M3 J9 ISH2 2nd AUG_PT2

Okay. Thank you, ladies and gentlemen. Think we're all back. So I will resume this hearing at 1135 and continue with our discussion about air quality. Um, item two on the air quality agenda is construction phase impacts. Um, so a question to Winchester City Council. In your local impact report, you state that there's a commitment to the Section 61 Control of Pollution Act 1974 and prior consent is welcomed and early dialogue is requested with so that the Council can be satisfied that mitigation during construction delivers and will provide the level of mitigation assumed within Chapter 11.

**DRAWING TITLE**  
 FIGURE 2.5 - THE SCHEME: TEMPORARY TRAFFIC DIVERSION ROUTES  
 APFP REGULATIONS 5(2)(a)  
 SHEET 2 OF 12  
 DOCUMENT REFERENCE 6.2

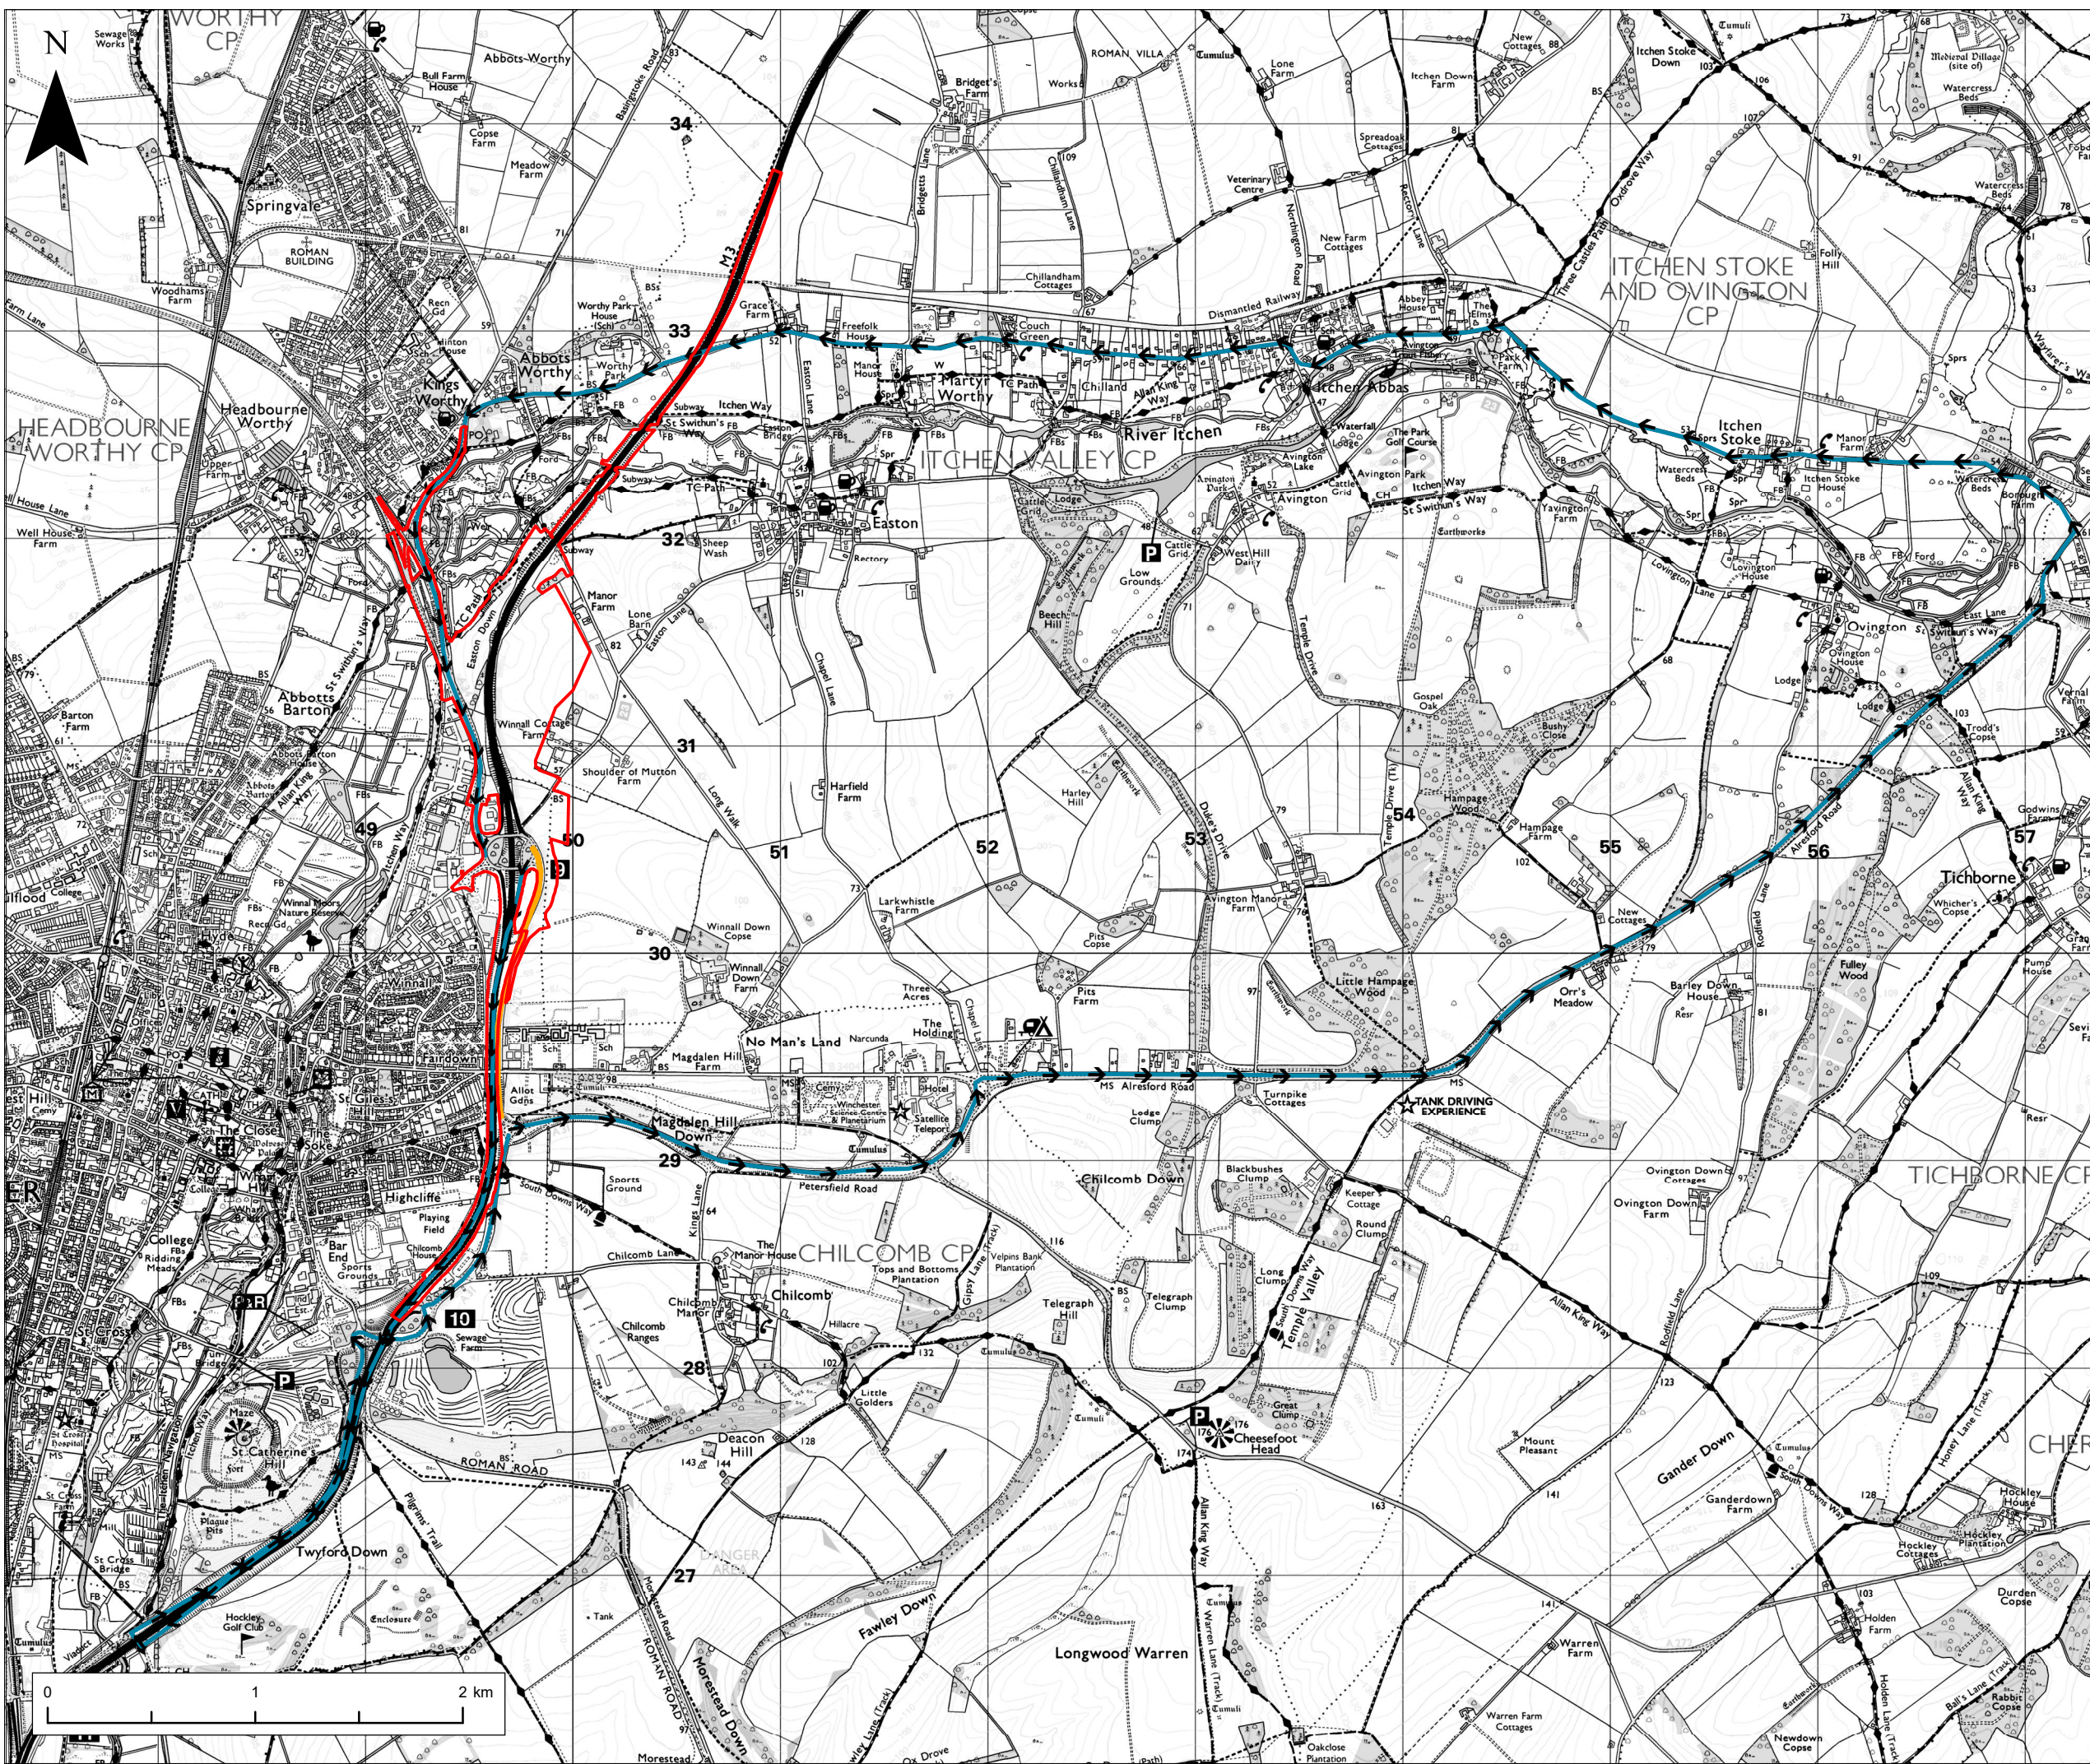
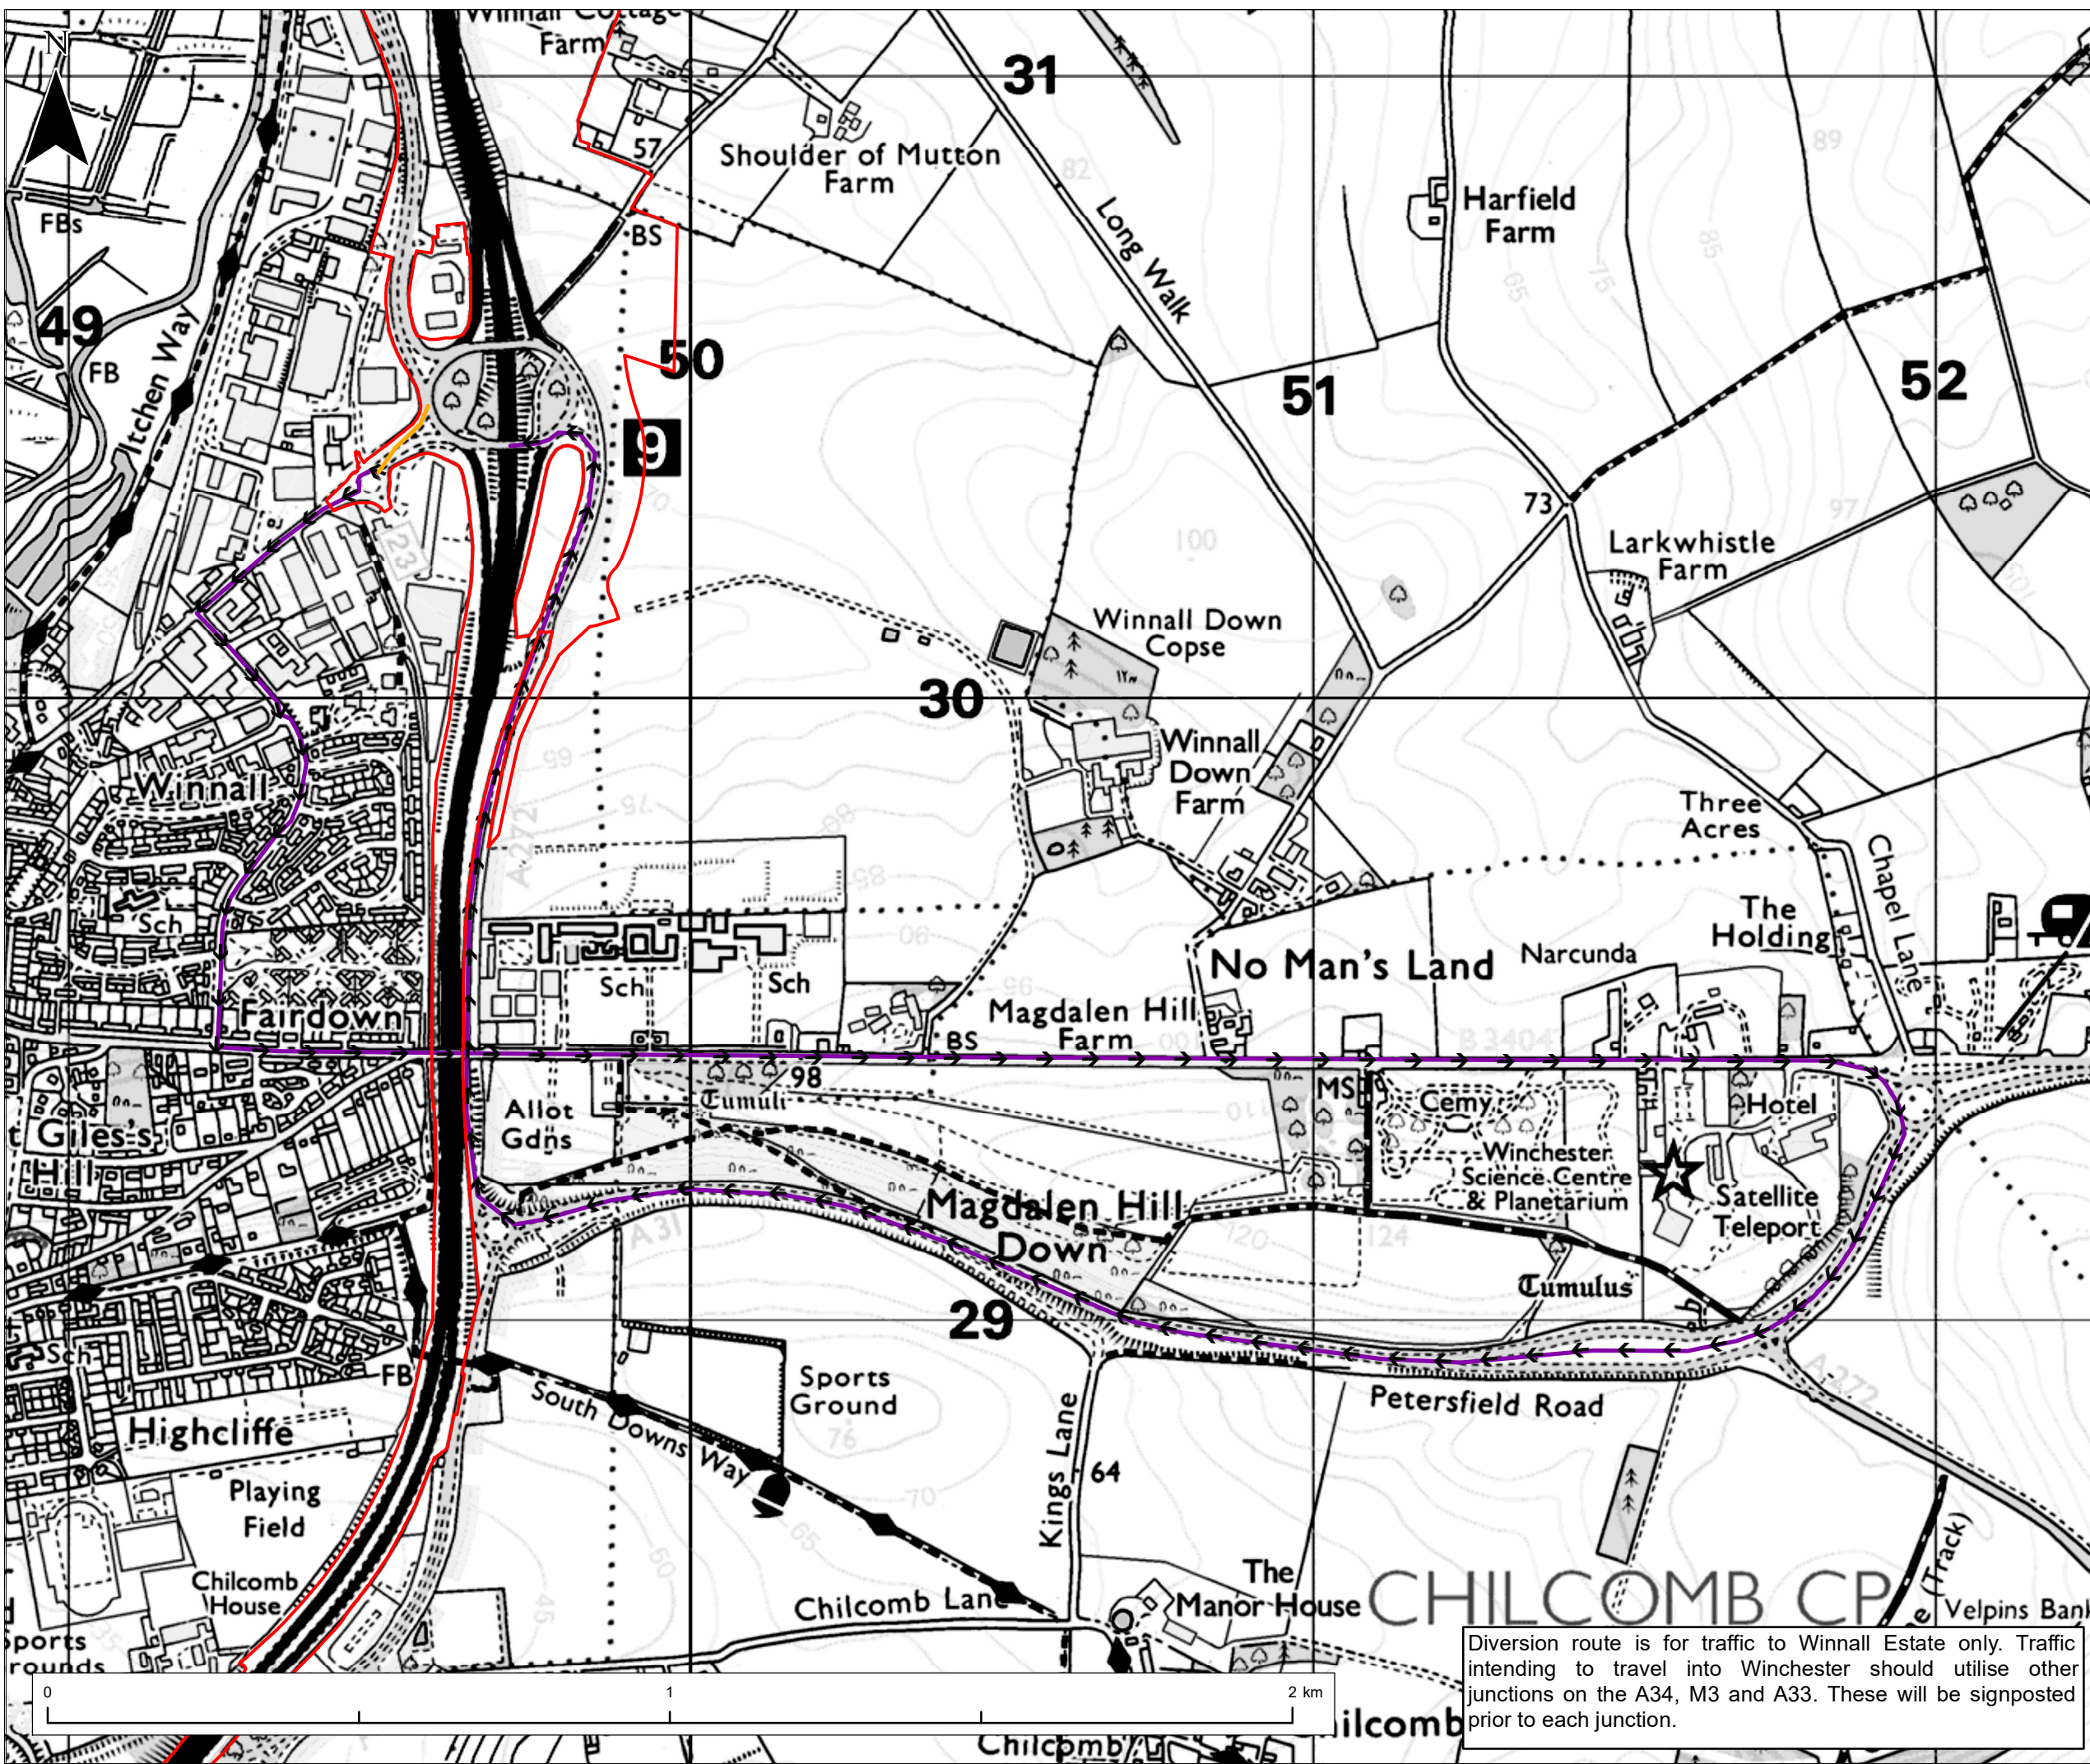
So so on the understand, we're talking about equality in more general terms. Um, we've already raised our concerns about potential adverse effects within the, um, during the construction phase for both resulting from traffic diversions and potentially in the days of Google and similar other things, the voluntary rerouting that people perform due to congestion. And that's of concern during the construction phase. Um, we've noted the applicant's comments, um, on our, our 102 page 72 of the applicant's response to relevant representations.

But we don't feel that satisfactorily answers our concerns. So still no reference to air quality impacts within a detailed diversion assessment methodology methodology. And we'd request that such criteria is listed and considered and reviewed as part of that consideration.

We had filters at Winchester City. We do have some concerns in relation to the methodology with the the assumption of or diversions will be followed in the modeling methodology performed, which in reality I think we would all agree it's not the case and particular reference, we'd just like some more work done on that. And in reference to the consideration of the including in a diversion assessment, some reference to air quality which still doesn't exist.

So we'd like that to be more formally acknowledged. The overall methodology, yes, but we do have we have no issue with it in a high level, but we do have issue with that that detail in terms of the way they've assessed the divergence and the impacts and particular reference to a potential daytime diversions and and congestion and acknowledge that will be try to be limited. And the assessment demonstrates nighttime closures.

But I think we need to see more work on the bits where that won't be the case and more discussion and assessment of that, sir.

both through the sort of the main construction period when the northbound on slip is closed and the potential for diverted flows then. But we've looked at that and really because that northbound on slip is not heavily trafficked, that kind of redistribution of flows doesn't lead to a risk of air quality impacts. You then have the sort of the closure diversions and closure routes discussion that we've we've touched upon. But again, there's the sort of the overnight closures etcetera, aren't considered likely to lead to air quality impacts because we're looking at sort of the annual air quality conditions and these occasional overnight closures and diversions aren't considered a risk from that that regard.

Yeah. Katherine Tracy for the applicant. Happy to continue to have the dialogue as part of the statement of Common ground and and flesh it out outside of this process, the hearing. Um, but in terms of the diversionary routes, um, they will, as we explained yesterday, subject to some sort of emergency closures, will be overnight or extended weekend closures, limited number of them during the construction period. The only long term closure is the M3 junction nine on the slip.

Um, and that has been modeled to and the modeling suggests that actually the number of vehicles that we use that won't generate significant impacts on, on the traffic network that would lead to any significant air quality impacts across the network. Um, however, we can work to flesh out that response if it's not currently to the satisfaction of Winchester City Council in terms of diversion routes and the joys of taking people on whichever route that the satnav considers is appropriate.

That is not that's an endemic problem that every traffic scheme and including, you know, Winchester local closures and things will have. So we can have a discussion about that. But I'm not entirely sure that that's within the bounds of the developer to to fix. We will be monitoring diversion routes that we put in place. Um, drivers and alike tend to stick to them now. Think they've learned the errors of their ways with satnav. Um, but that it is possible during monitoring for additional traffic management measures to be put in place.
